25 April 2025

Subject: **Tendring District Council (TDC) Representation – Deadline 4 Submission**

**For the attention of NSIP Case Officer- National Infrastructure (Energy) dealing with the North Falls DCO application**

Indicative Sections

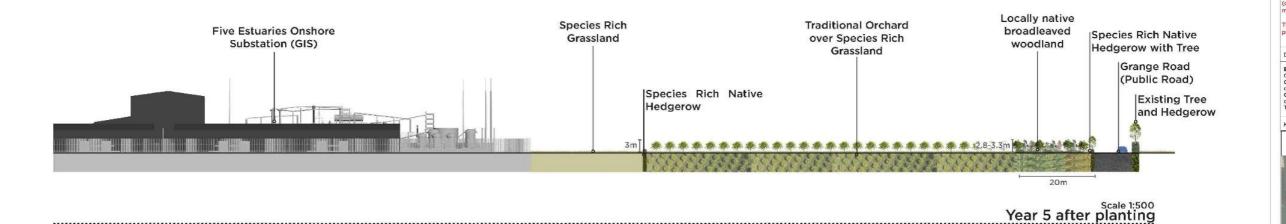
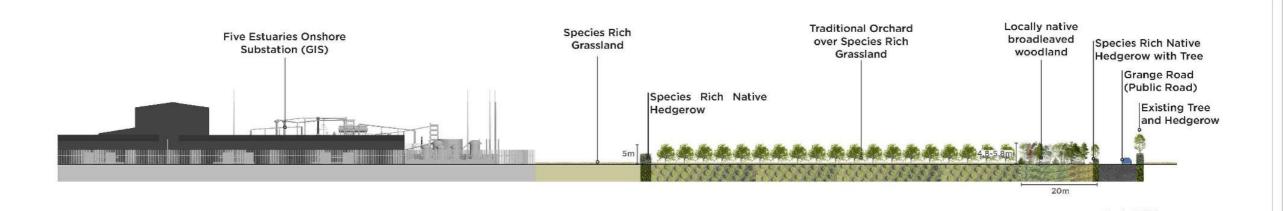
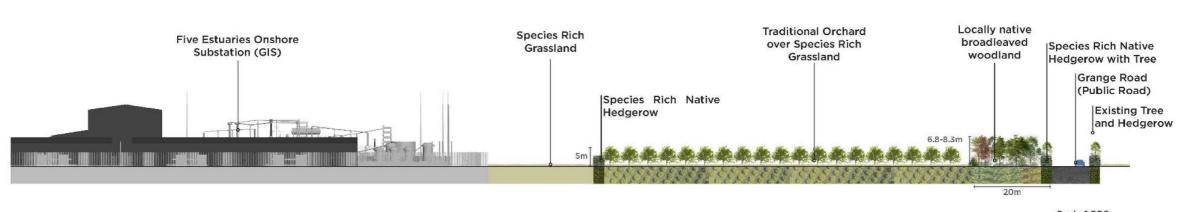
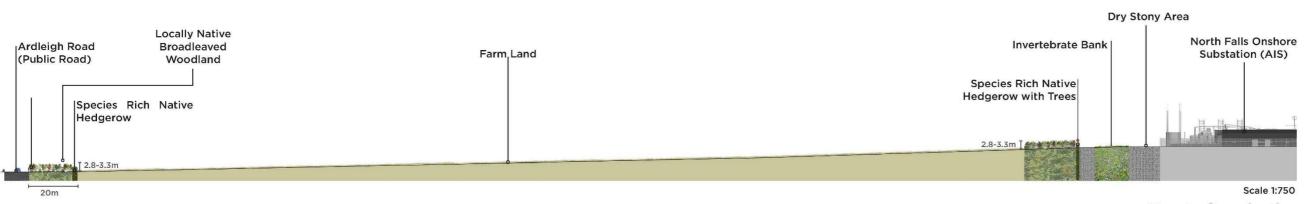
TDC prefers the North Falls screening approach at Normans Farm due to its lesser impact on agricultural yield. However, we note that both proposals (North Falls and Five Estuaries) are only partially effective—screening cannot fully obscure infrastructure of this scale. Again, this highlights the need for clear, enforceable mitigation and balanced decision-making.

# **Onshore Substation Zone of Theoretical Visibility and Viewpoint Locations with Dedham Vale National Landscape**

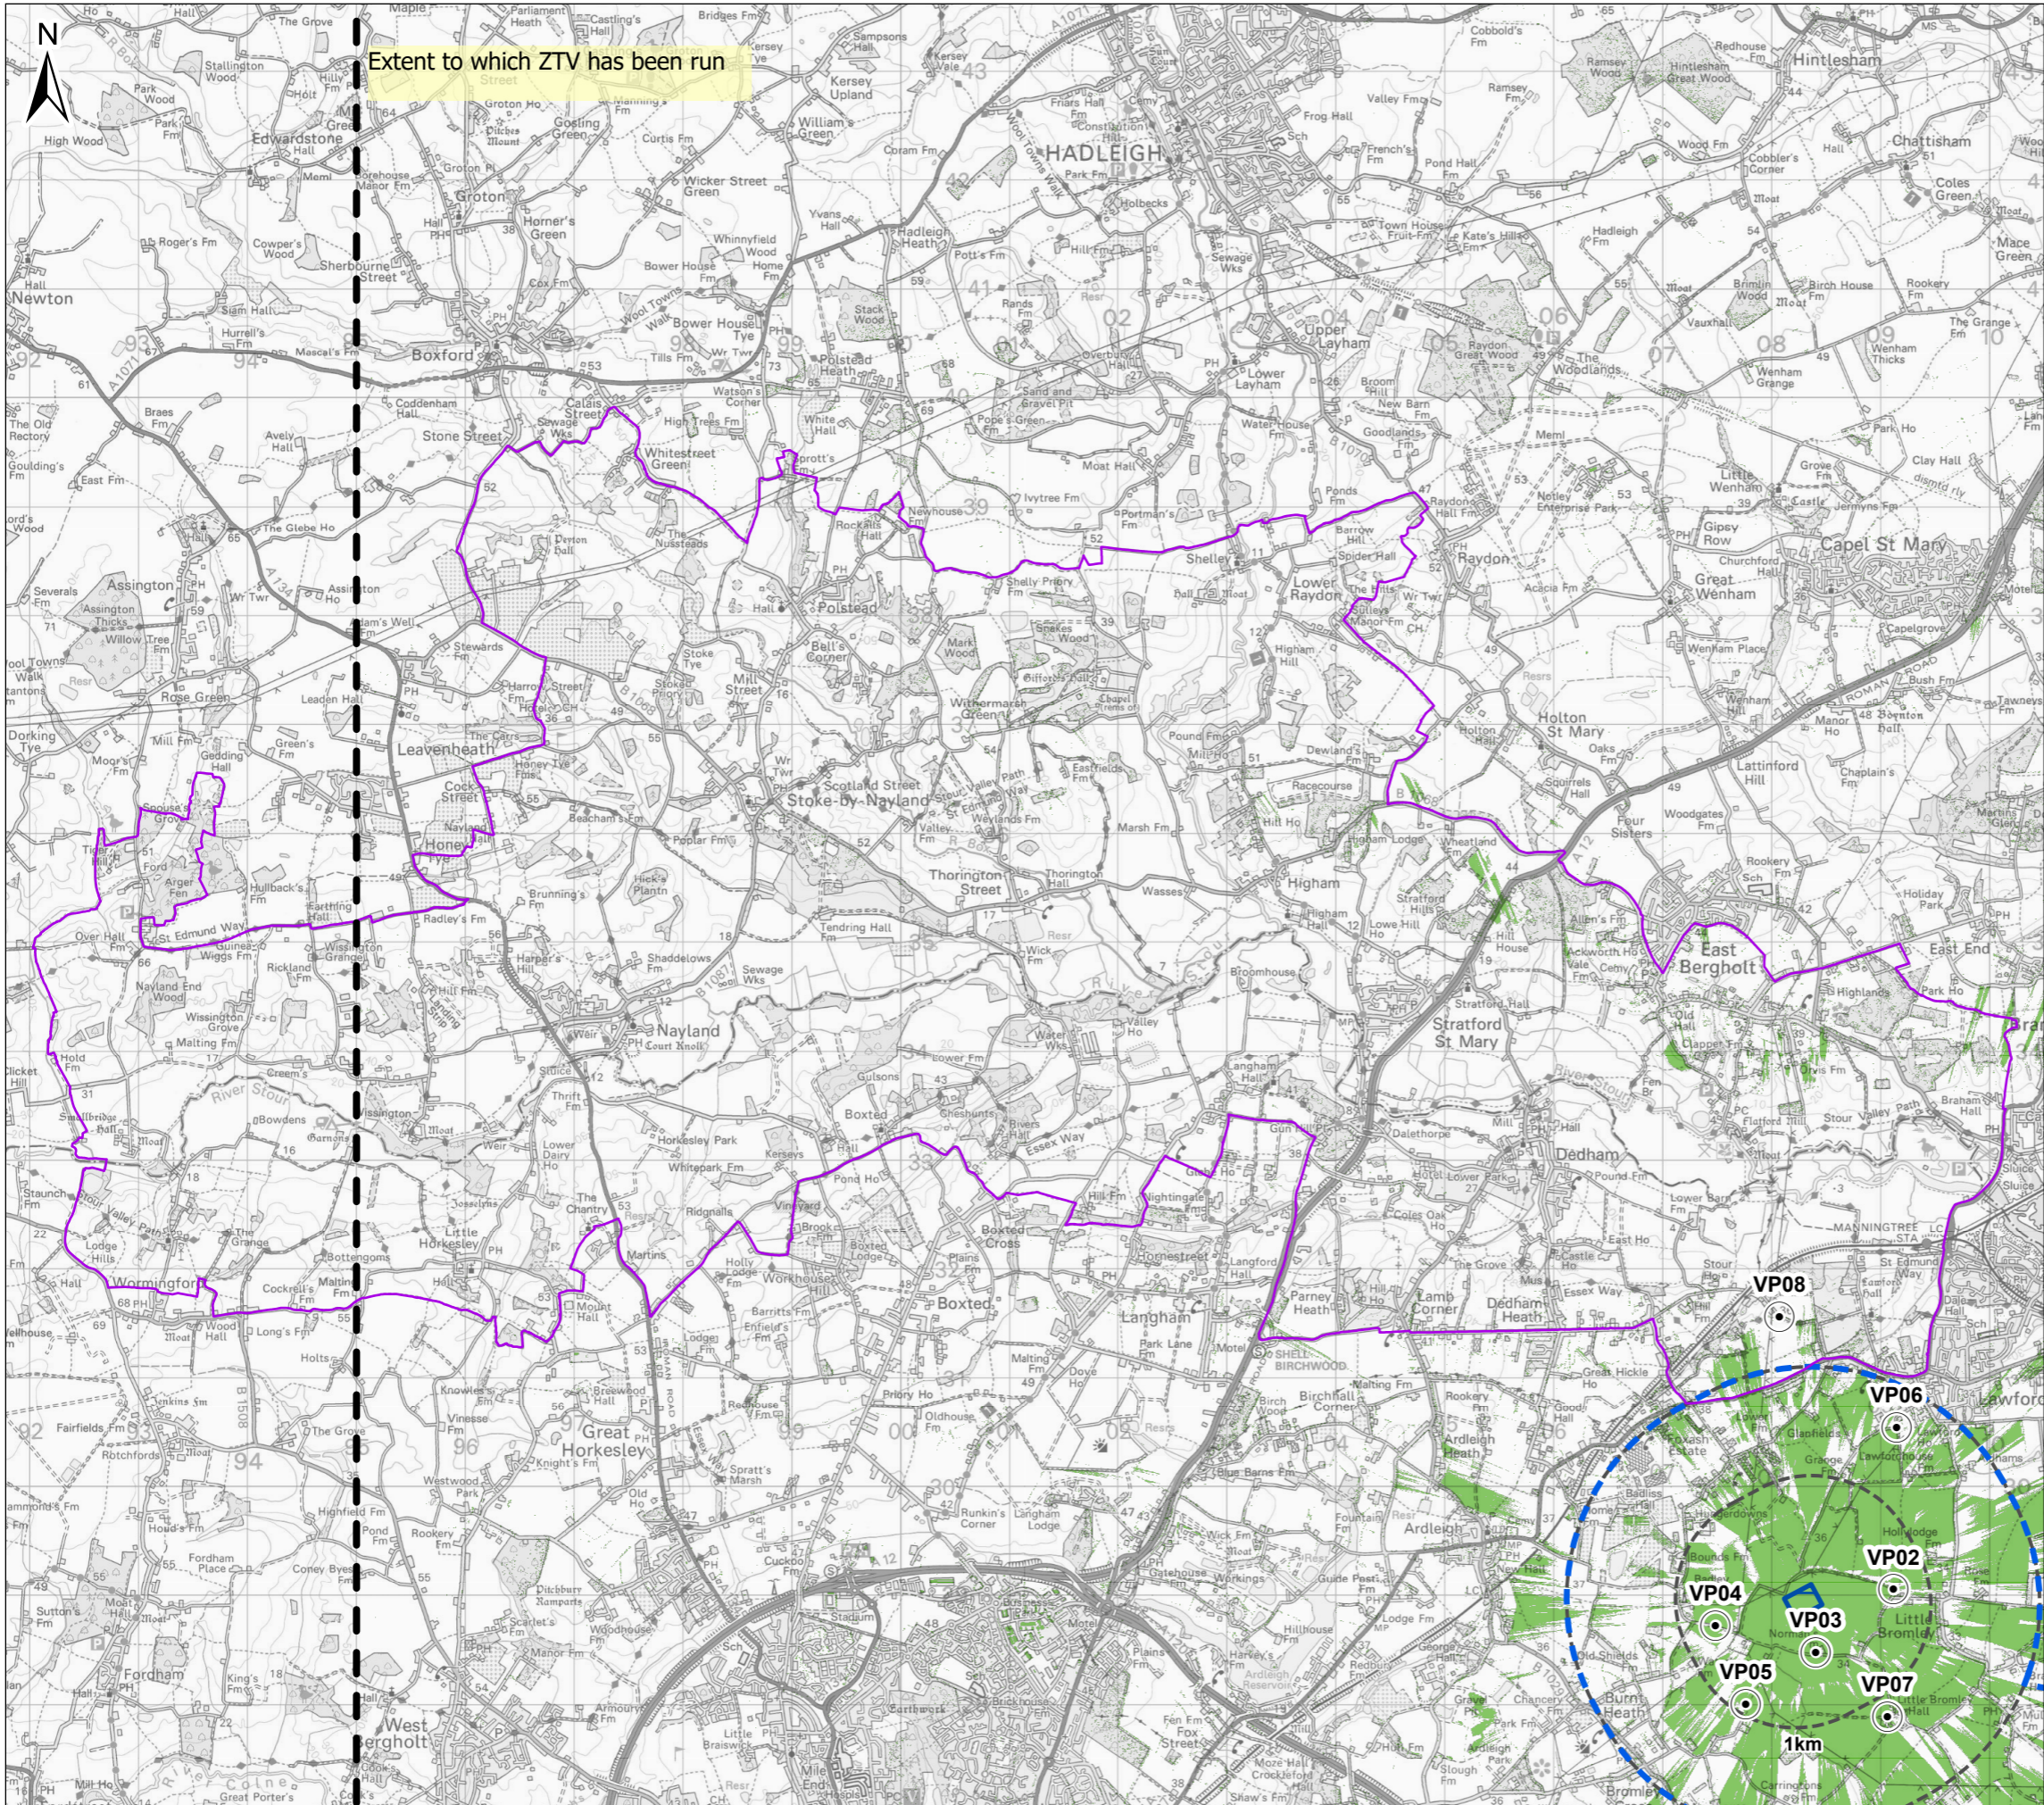
TDC was asked to clarify the extent of the National Landscape, particularly regarding VP08. We confirm that:

- The boundaries are accurately represented in the map titled 'Information Plan', Drawing Number: 208886\_PLN\_INFO\_1123.1.
- VP08 lies within the Dedham Vale National Landscape—approximately 400m inside the boundary.
- The proposed substation lies just 1.8km away.

It is concerning that the applicant was unable to confirm this during the site visit. The combined visual and environmental effects of all NSIPs in the region—North Falls, Five Estuaries, Tarchon, Norwich to Tilbury, and EACN—must be thoroughly assessed.
